**Response from Wiswell Parish Council on  
Consultation on Variation of Condition 3/2023/0512.  
23 Pendleton Road Wiswell BB7 9DD**

<b>Date:</b>	24 July 2023
<b>Submitted by:</b>	Mike Hill. Clerk to Wiswell Parish Council
<b>Attention of:</b>	Emily Pickup <a href="mailto:planning@ribblevalley.gov.uk">planning@ribblevalley.gov.uk</a>

Front (South East) Elevation

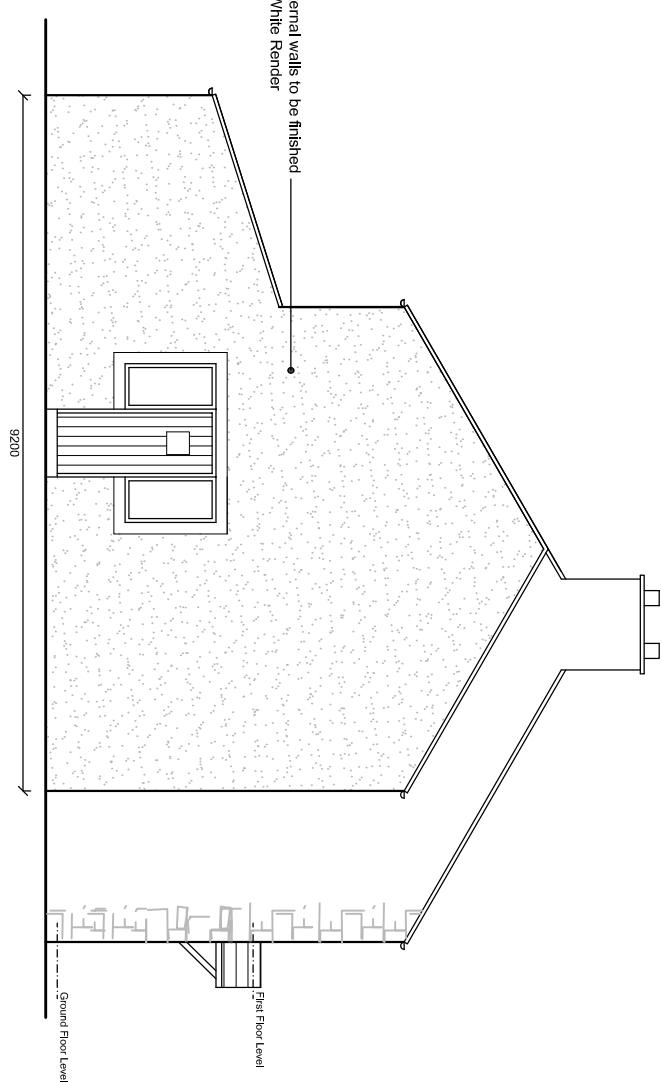
In the original application, the applicant demonstrated how they were complying with requirements of the RVBC policies, particularly DME4, and the principles and guidance of the Wiswell Conservation Area documents. We had hoped that the development would conserve and enhance the character and appearance of the cottage to match all the effort previously made on nearby properties. It is disappointing that the applicant is now seeking to replace the previously agreed random stone with white render, presumably for cost savings. In particular, the change to the front face of the extension will be very detrimental to the view of the extended property from Pendleton Road. The side and rear walls of the extension are less visible of course.
